Subject: RE: Planning Consultation on: BN/93/20/DOC

Application No: BN/93/20/DOC

Registered: 24th August 2020
Site Address: Flamsteed Lake Lane Barnham PO22 0AD
Description of Works: Approval of details reserved by condition imposed under ref BN/130/19/HH relating to Condition No 3 - surface water drainage.

Proposed Ground Floor

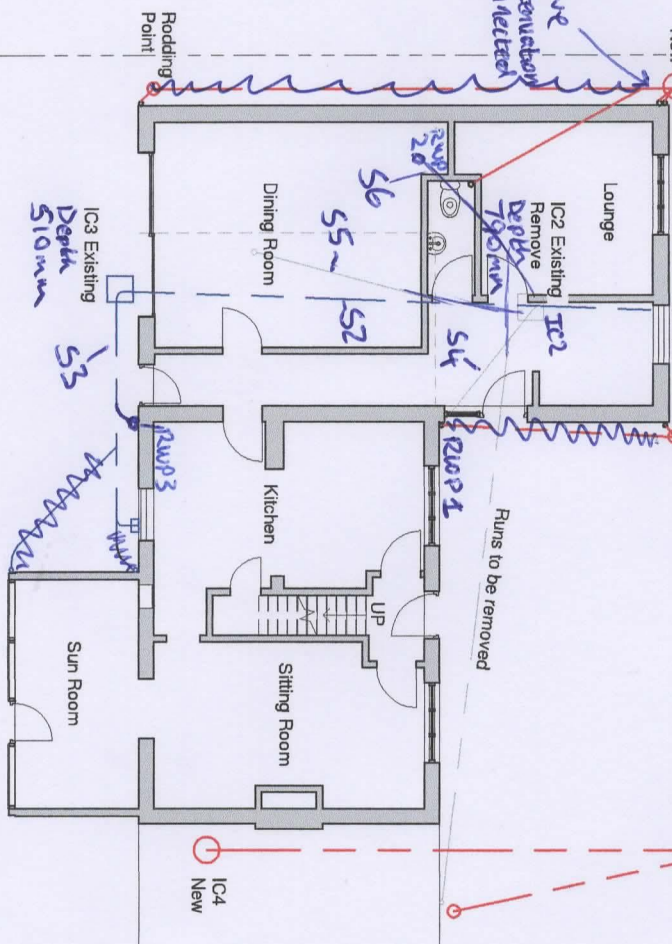
3. To satisfy the condition, the plans need to be much more detailed including the provision of construction detail drawings for the various elements. The layout plan needs to include all pipe diameters/gradients, manhole cover and invert levels, storage tank levels, etc.

5. Detailed construction drawings for the surface water drainage need to include manholes, rodding eyes, details of arrangements where the pipe passes under the extension (ie. IC3 to IC6) /through foundations, pipe bedding, gullies, storage tank (including connections and outlet arrangements) and flow control details. As the flow control device will probably be of a small scale, the design will need to consider measures to reduce the risk of blockage. Please note the preference would be for pipe run IC3 to IC6 to be routed around the building if possible.
6. Southern Water will need to be consulted further once more detailed proposals are available to ensure that the arrangements meet their requirements.
